Letter No.B3/3786/2018 , Dated: 24.07.2019

Sub: CMDA – Area Plans Unit - ‘B’ Channel (North) - Planning Permission Application for the re-construction of 2 Blocks Ground Floor +3 Floors Residential Building with 80 dwelling units at S.No.263 part, Sadayankuppam Village in Block No.83 of Manali New Town – Remittance of DC and other charges – DC advice Sent – Reg.

GROUND FLOOR PLAN

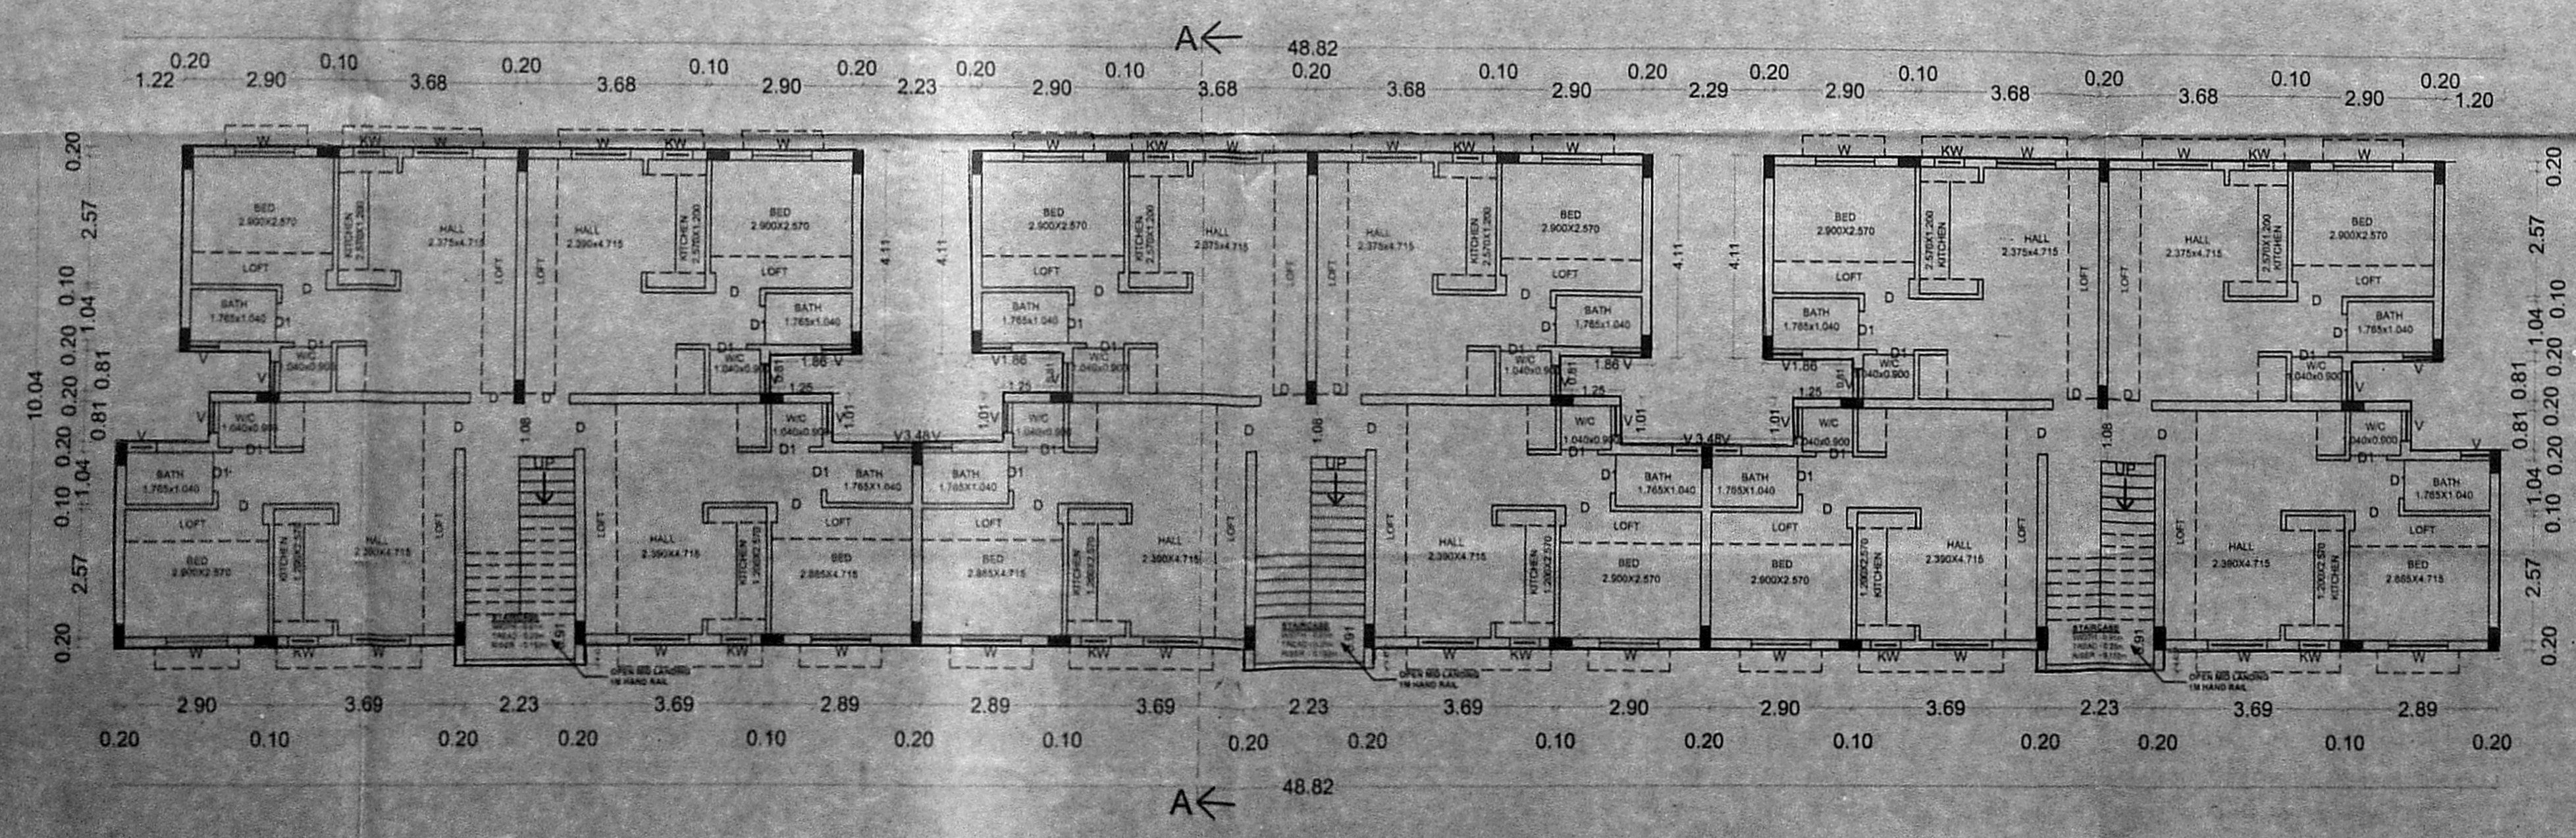
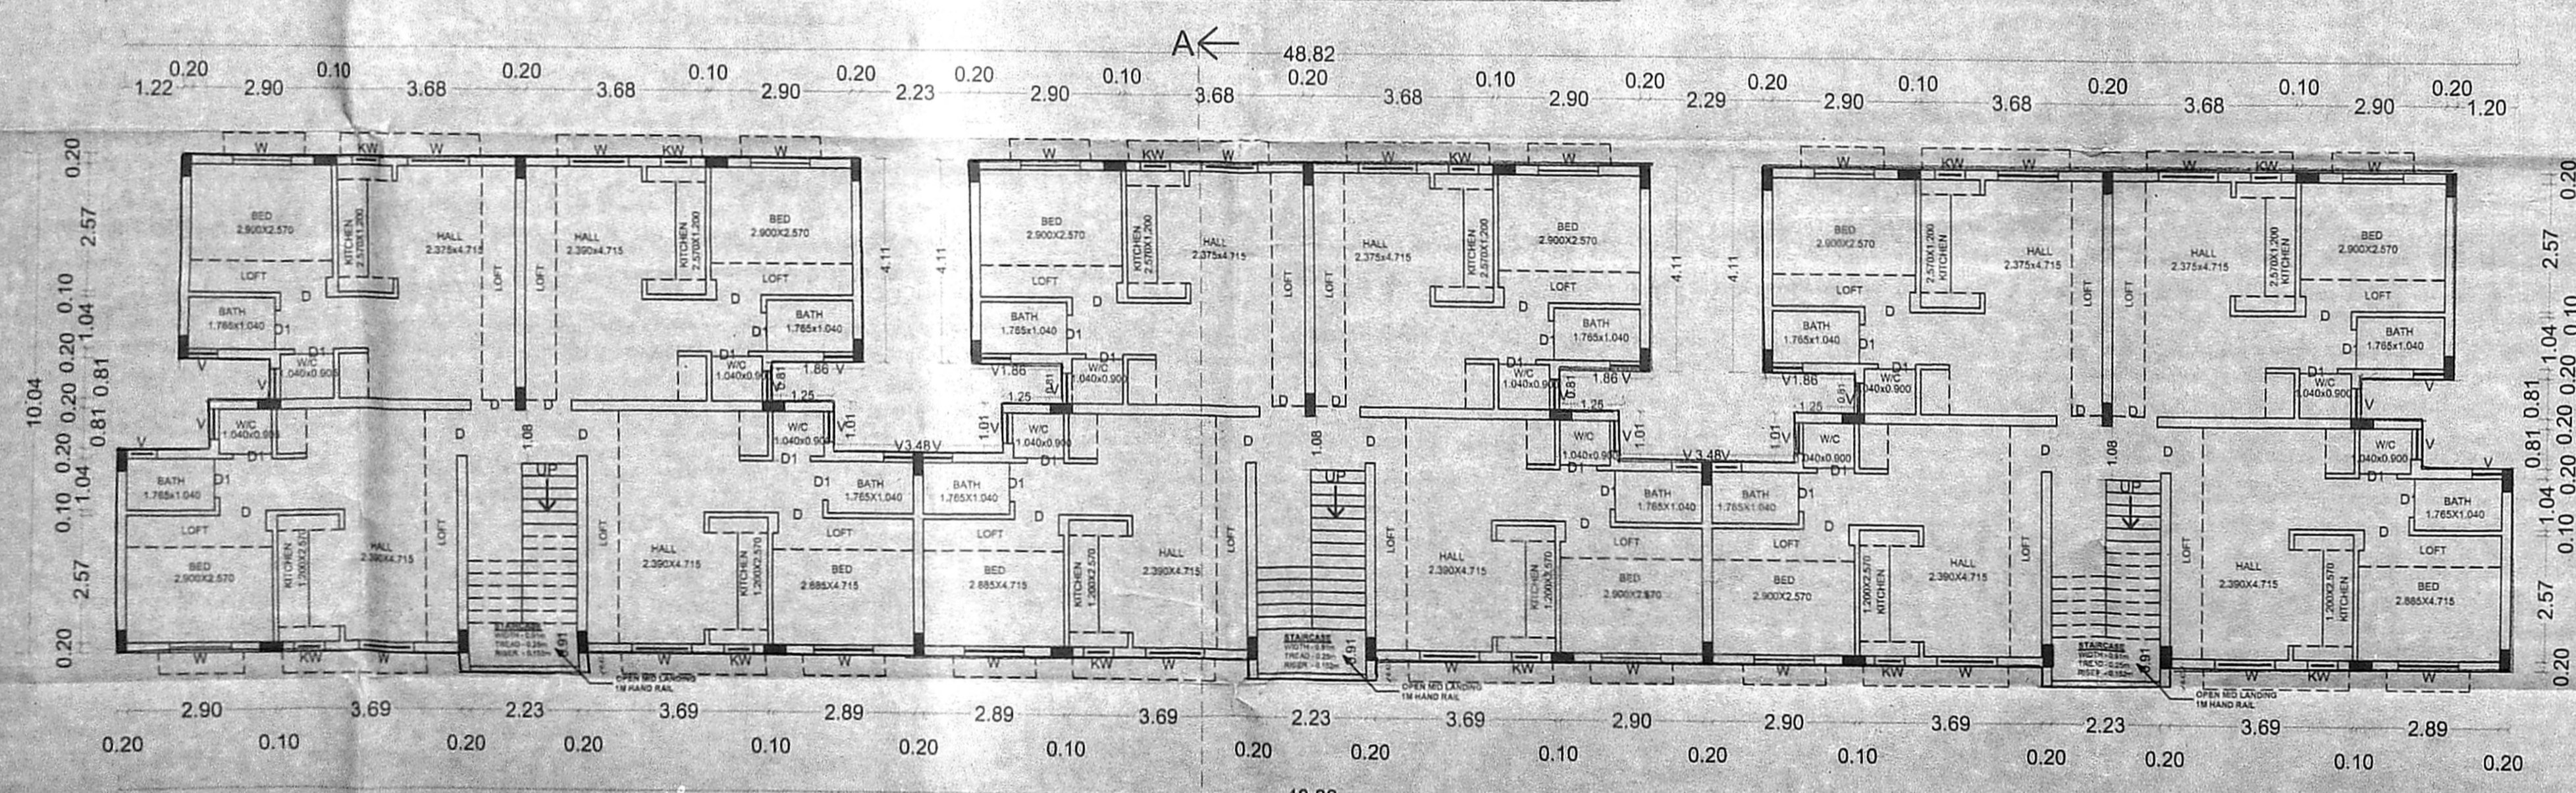
- e) Building breakup measurement and overall measurement to be shown in the eastern side of the floor plan.
 - f) Area statement needs correction.
 - g) Open mid-landing to be shown in the floor plan.

- h) Column position to be shown in the floor plan.
- i) Parapet wall height to be shown as 1.00m.
- j) Applicant should be sign in the front page of Form C.
- k) PP1 not furnished.
- l) Form B submitted in the name of TNSCB but signed by DP, TNSCB which is not acceptable.
- m) Person who has applied for planning permission sign in Form B, Form C, PP1, PP2 etc.,
- n) The same person should not sign to the capacity of applicant and License Surveyor.
- o) Same person should not sign in the applicant Structural Engineer, License Surveyor, PP1, PP2 and plans.
- p) Rainwater harvesting to be shown in the plan.
- q) The site plan in readable scale to be furnished.
- r) Splay to be shown in the site plan.
- s) Qualified Structural Engineer to be signed in the PP1 & PP2.
- t) Road width to be correctly mentioned in site plan.
